From: Biazar, Shahab
Sent: Tuesday, January 26, 2016 11:28 AM
To: Yolanda Padilla Moyer; Chris Sholtis; Kevin G. Patton (kevin.patton@pultegroup.com)
Cc: Harmon Rita T. (rharmon@cabq.gov); Abiel X. Carrillo (acarrillo@cabq.gov); Elliott, Stanice (staniceelliott@cabq.gov); Cherne, Curtis
Subject: DEL WEBB Phase 2, Tract M off the Watershed Subdivision (H09D017F)
Attachments: stormwater control_ESC_Permit.pdf

Based on the DMP submittal for DEL WEBB Phase 2, Tract M off the Watershed Subdivision (H09D017F), the plan is approved for Preliminary Plat but the following comments must be addressed prior to grading and workorder approval:

EXISTING BASINS MAP

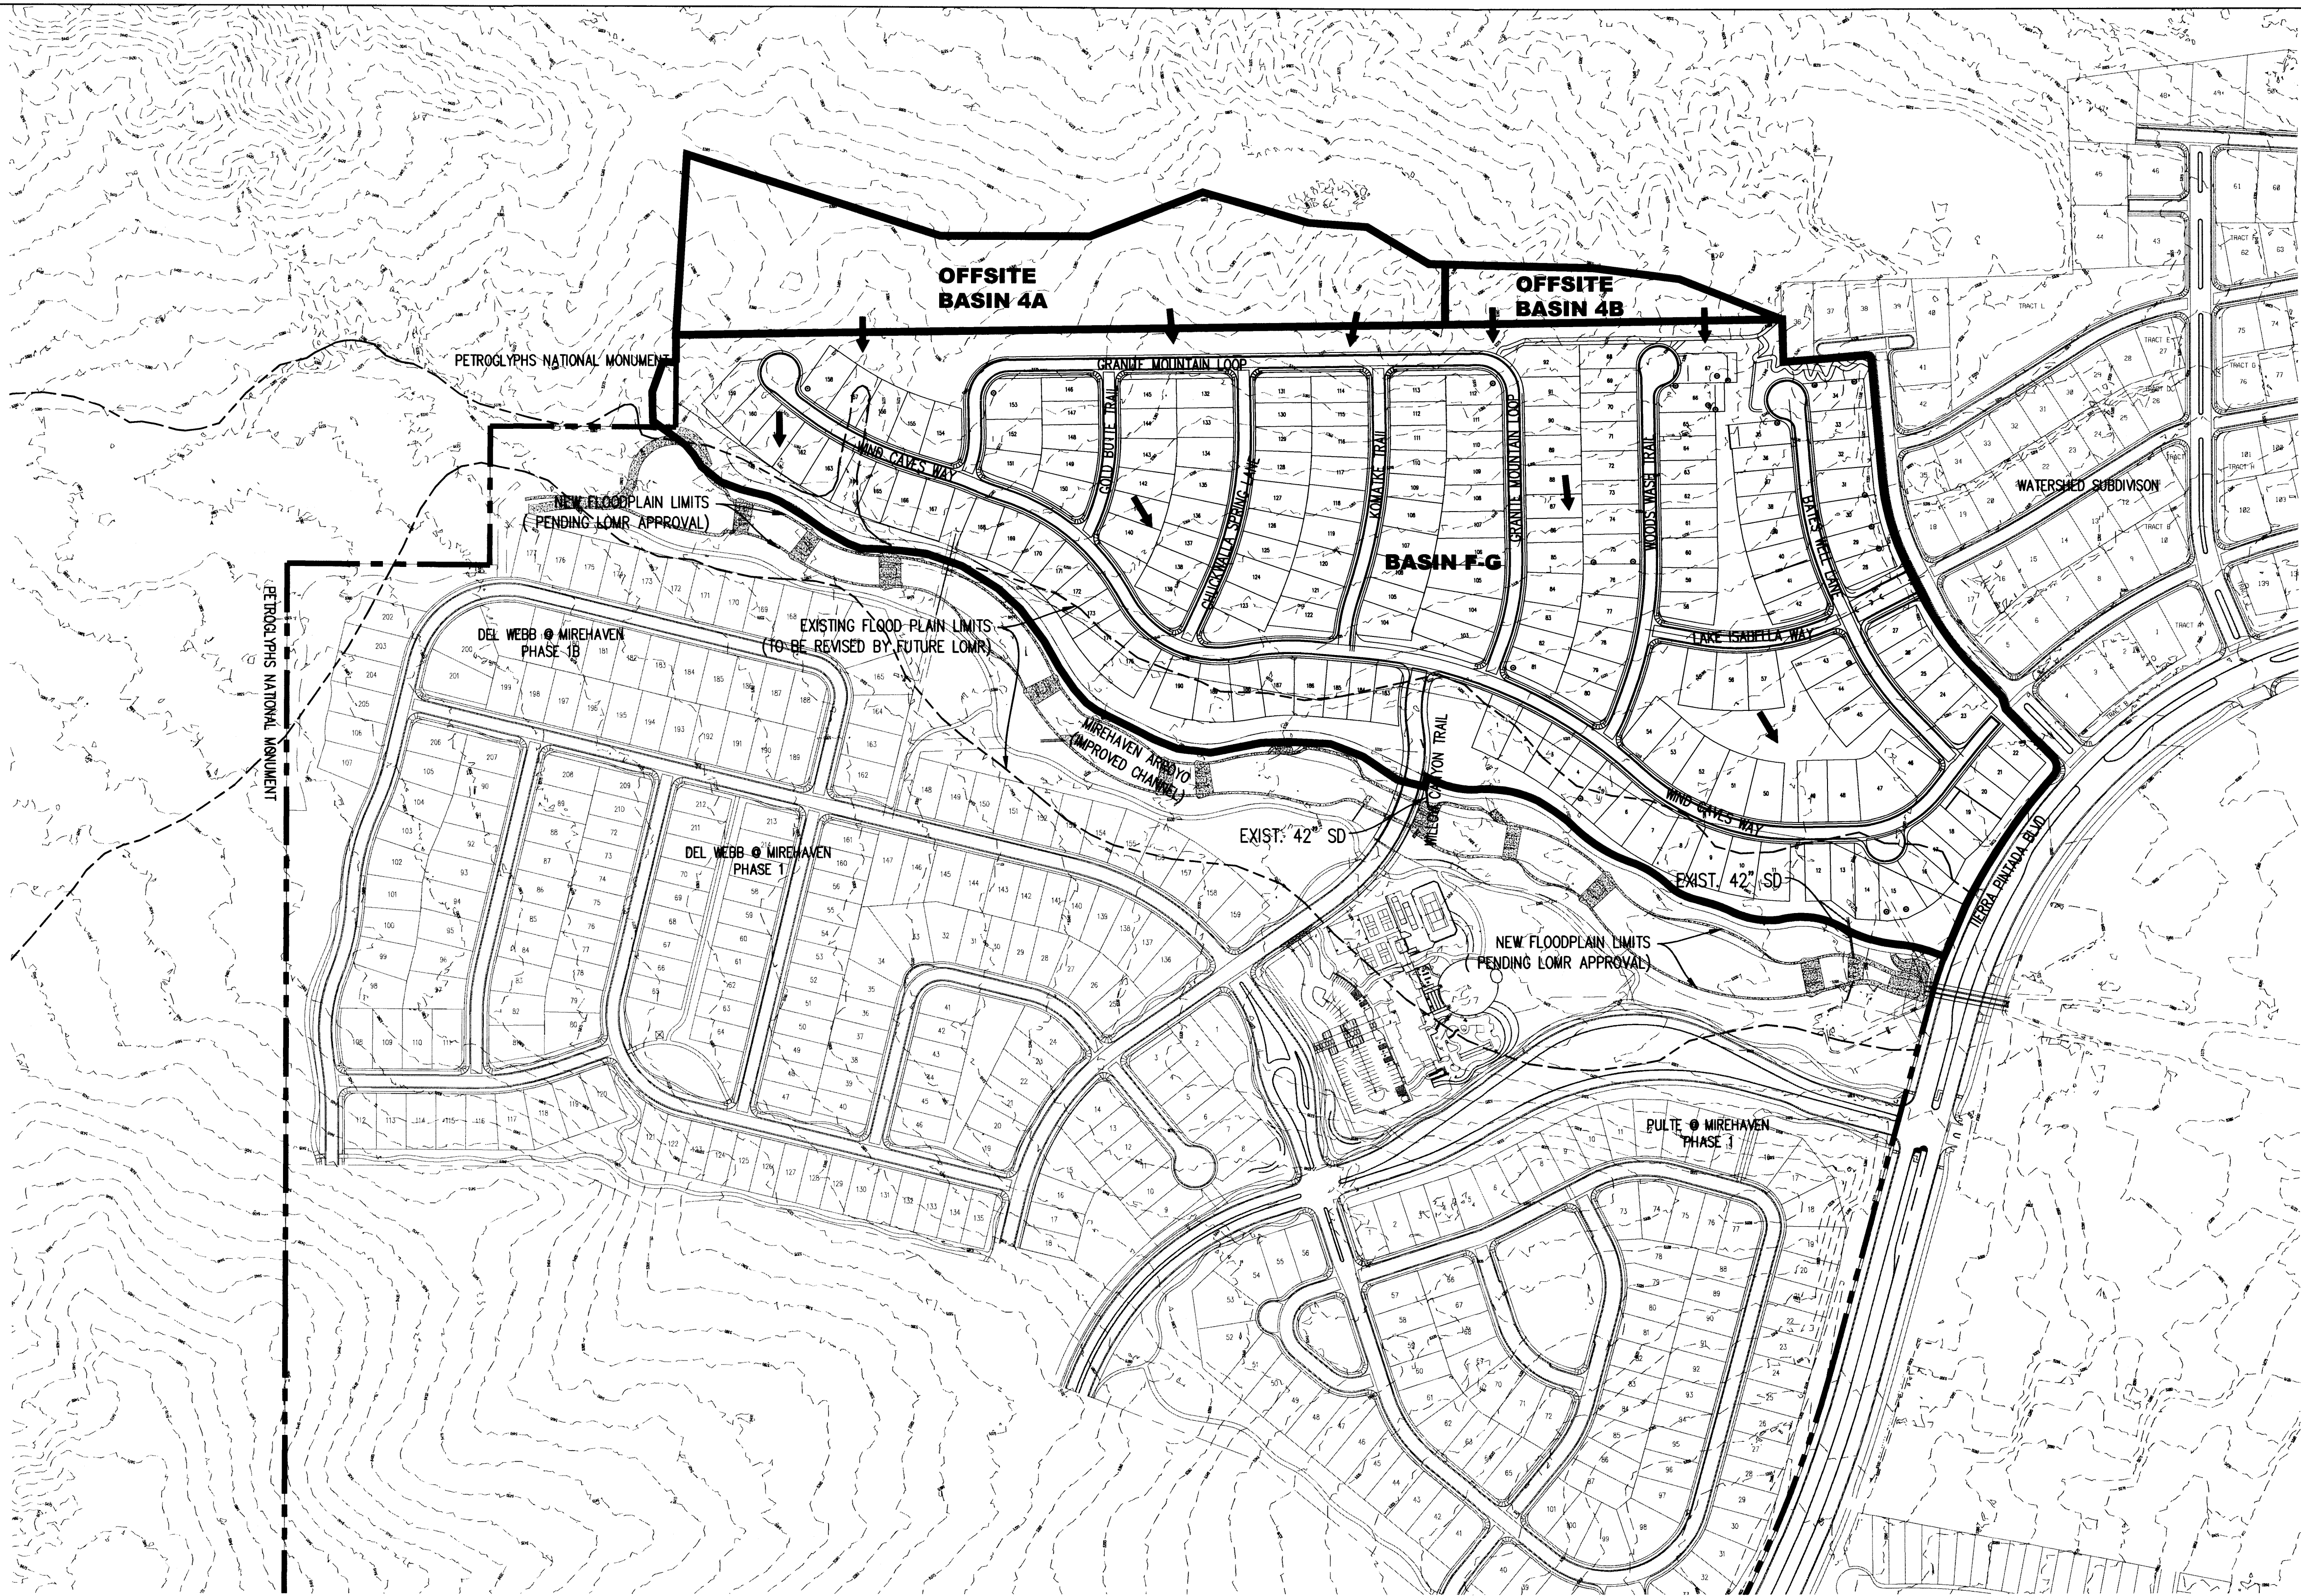
- Provide existing topography beyond the property line on the east side. Elevations must be provided for existing improvements to assure proper proposed grades will not any adverse impacts.

FRONT YARD POND DETAIL
FOR LOTS DRAINING FORWARD

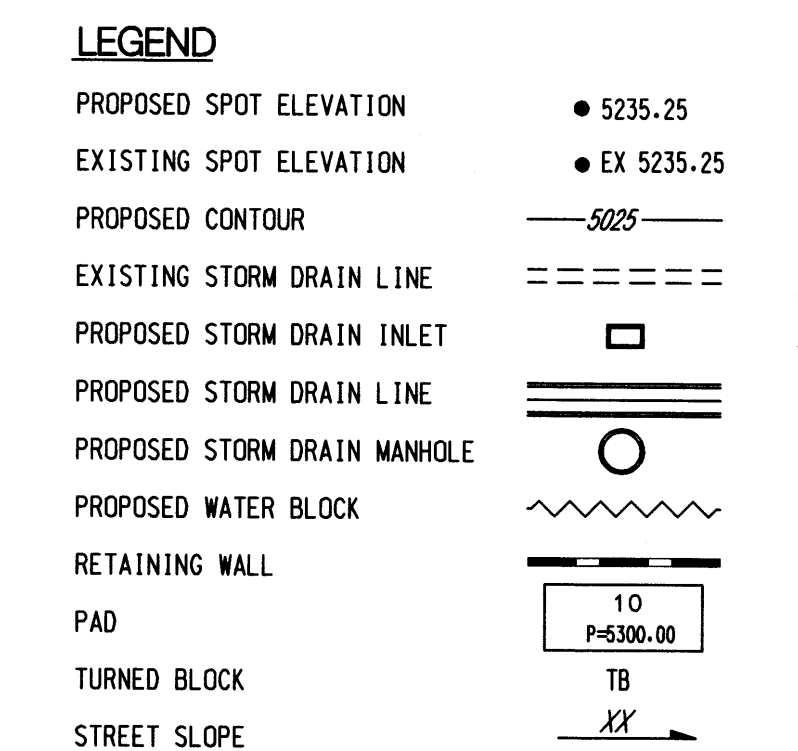
- Include details for the offsite runoff conveyance over the wall and the path/swale to the street.
- Provide overall first flush calculations and typical lot ponding exhibit including ponding calculations for the different lot sizes.

DEL WEBB @ MIREHAVEN PHASE 2 PROPOSED STORM DRAIN NETWORK

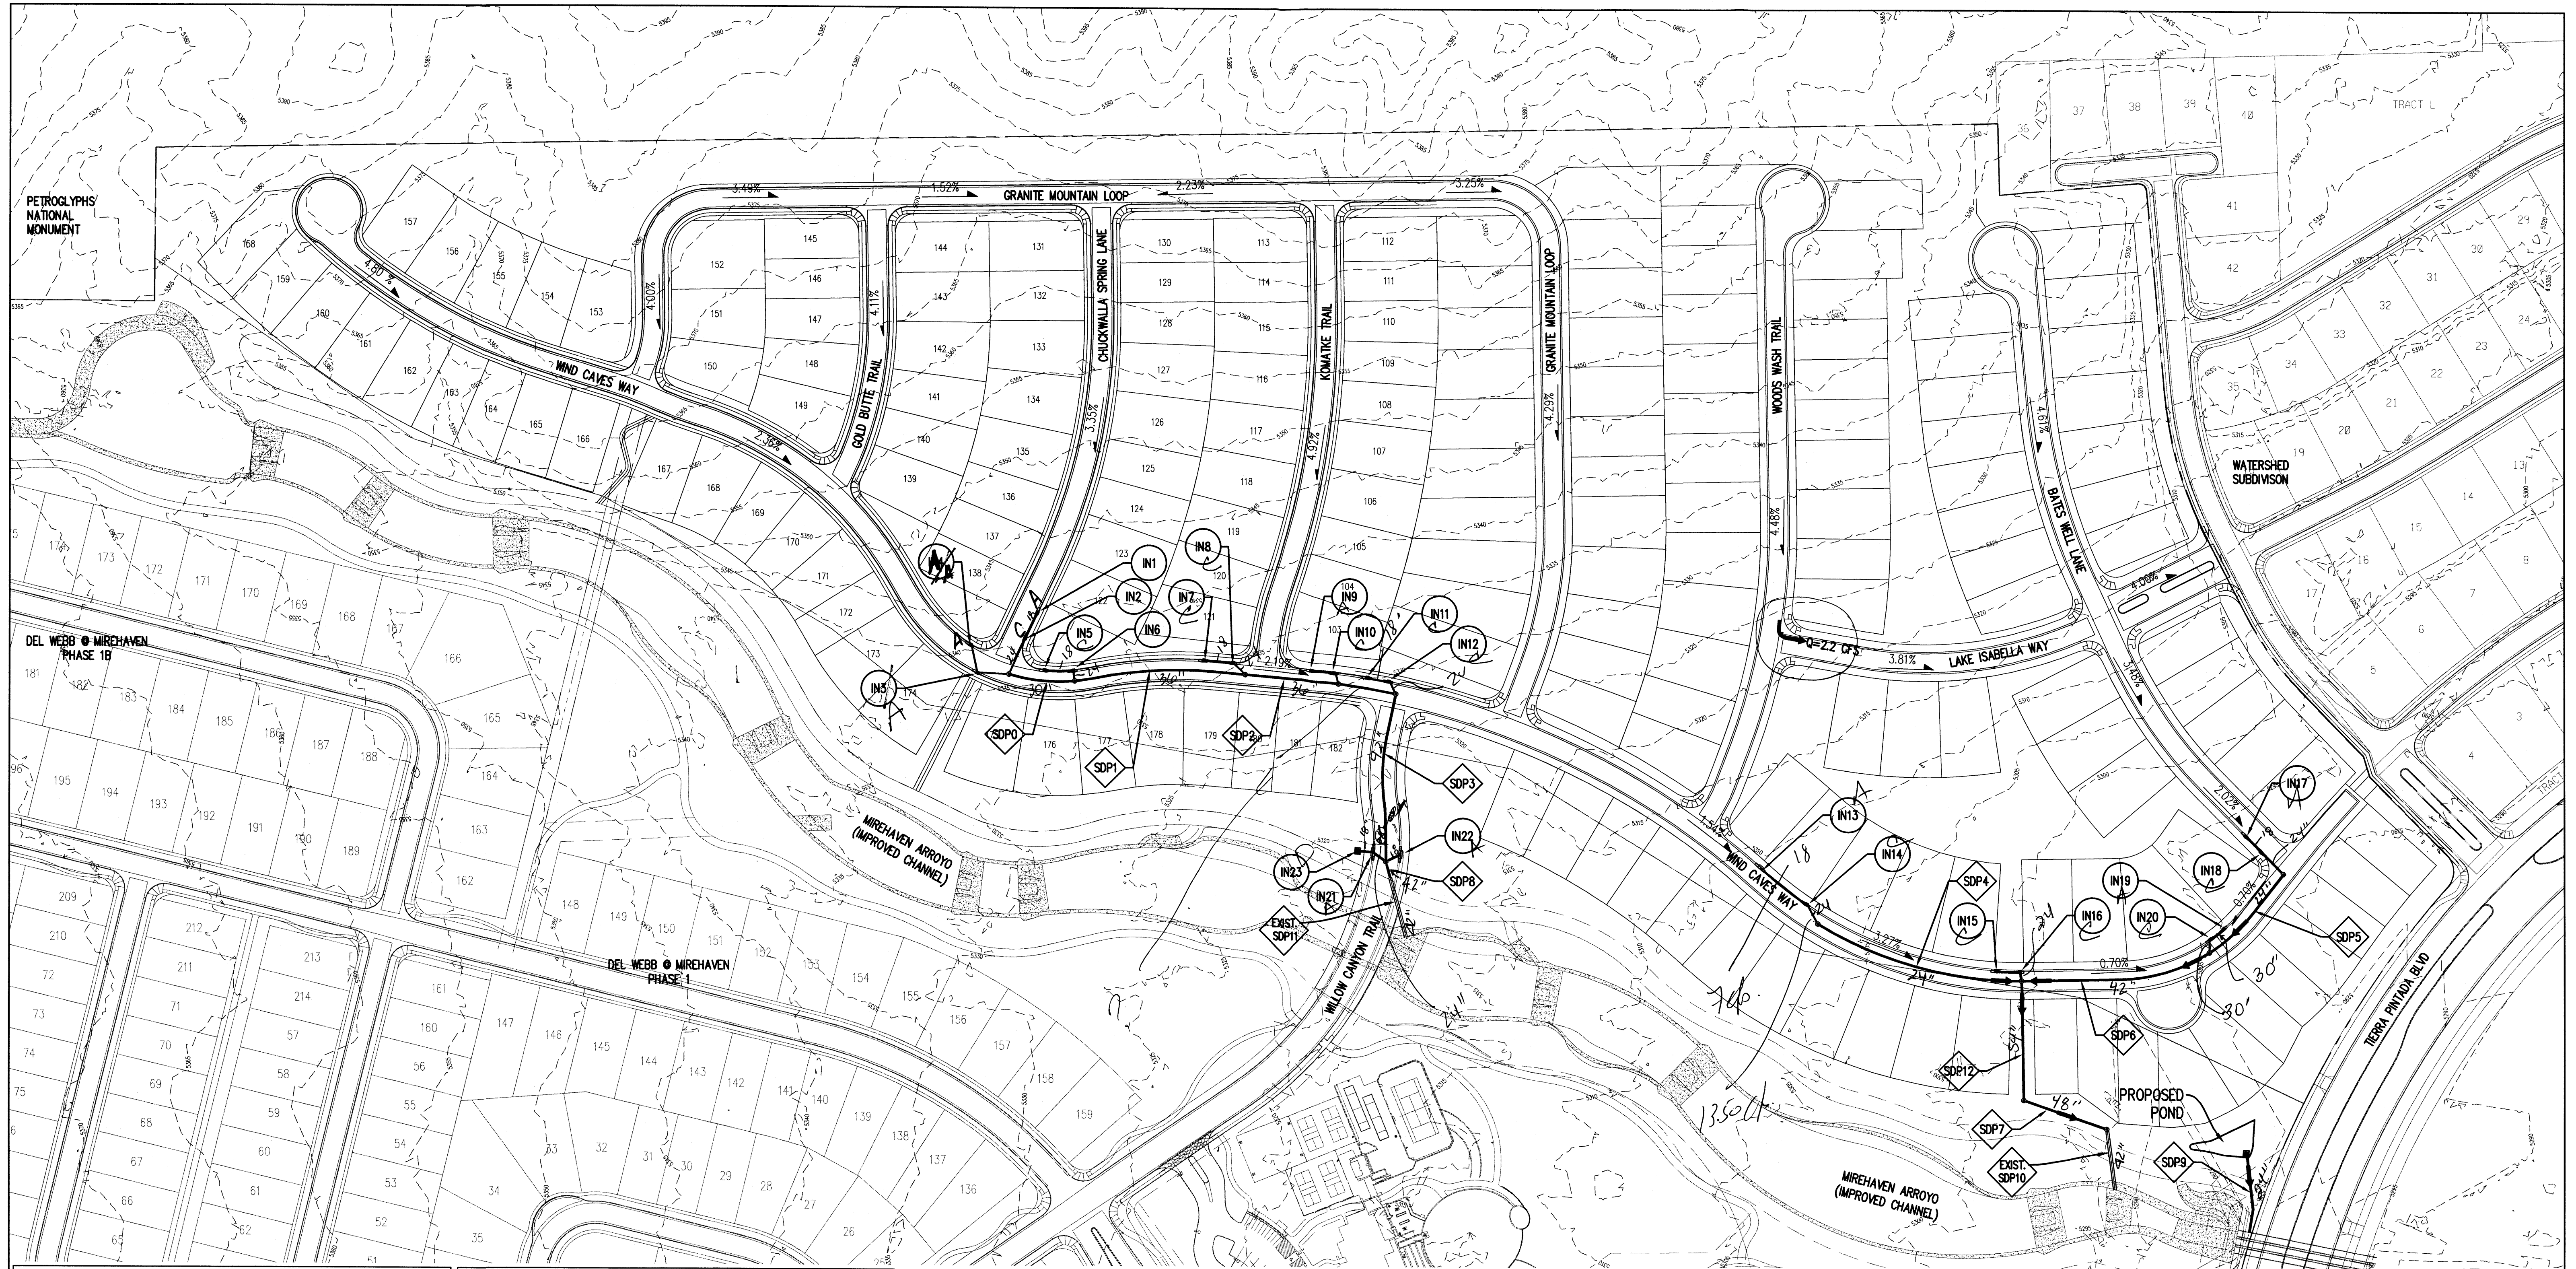
- Provide pipe sizes for all the storm drain pipes.
- An Erosion and Sediment Control (ESC) plan must be approved prior to grading approval.
- Stormwater Control Permit for ESC will also be required prior grading approval.

DEL WEBB @ MIREHAVEN PHASE 2
PROPOSED BASINS MAP

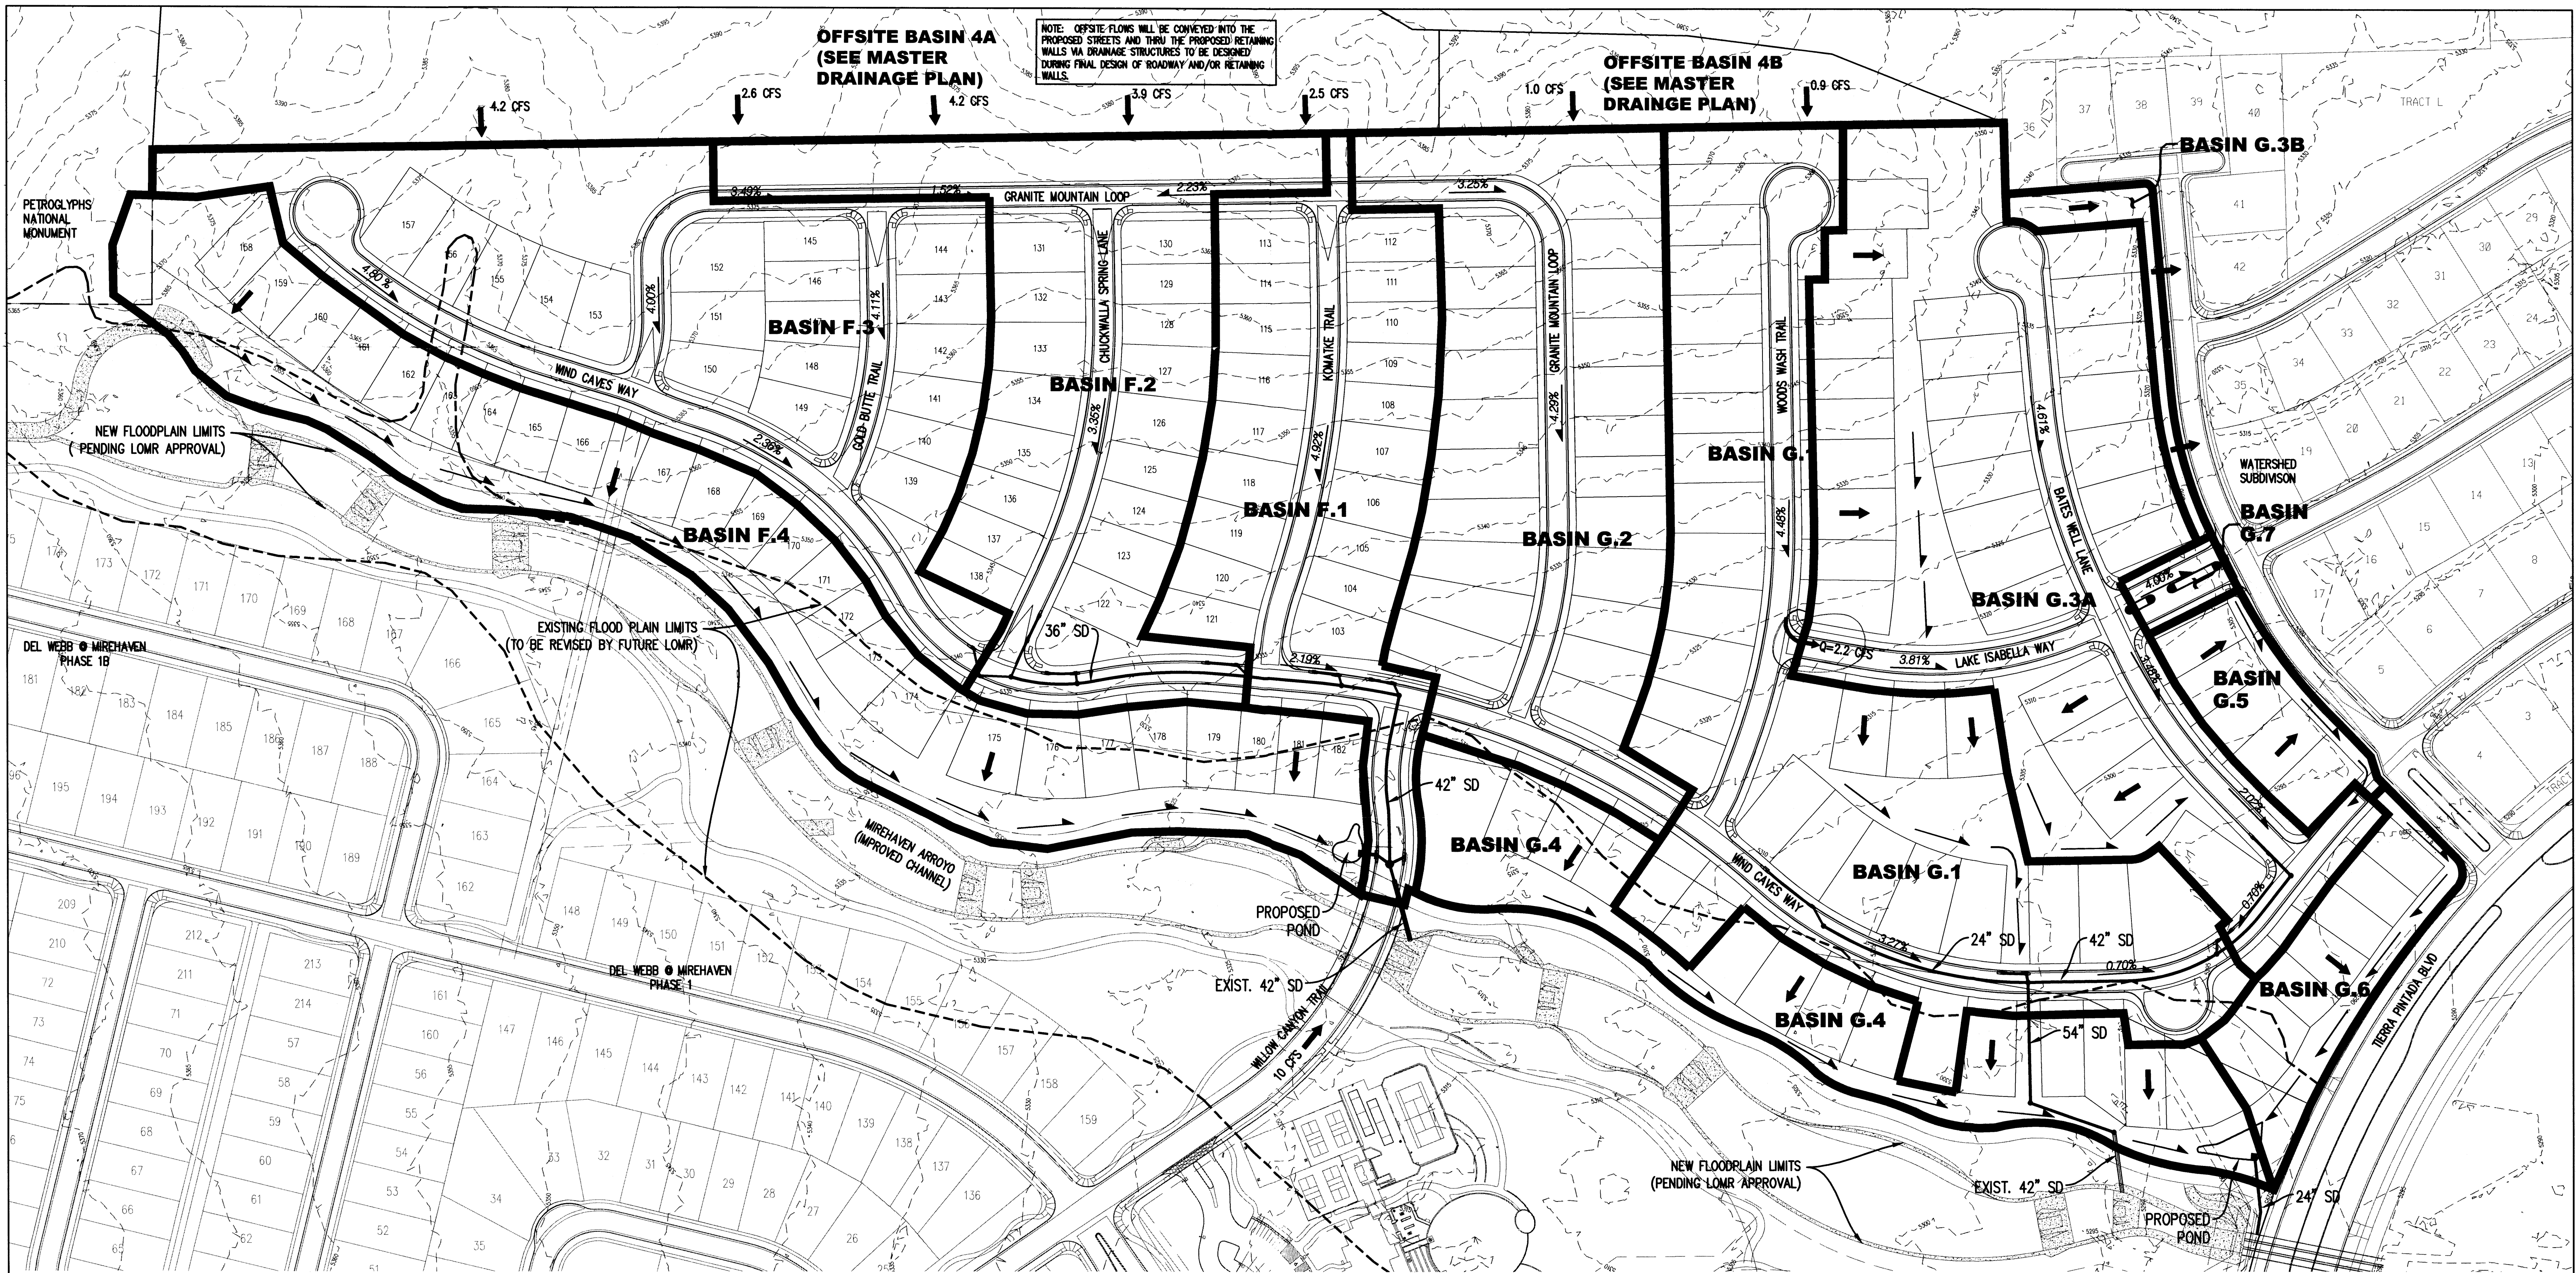
- Part of Basin G.3 drains Basin G.1. How would this impact street capacity and proposed inlet location?
- Provide wall sections (including swales if any).

- North end of Basin G.3 and Basin G.7 drain to Westcreek Pl. How will this impact street capacity and downstream storm drain structures.
- Please update proposed Basin map according to the proposed drainage patterns. Please make sure street capacity reflects the actual flows.
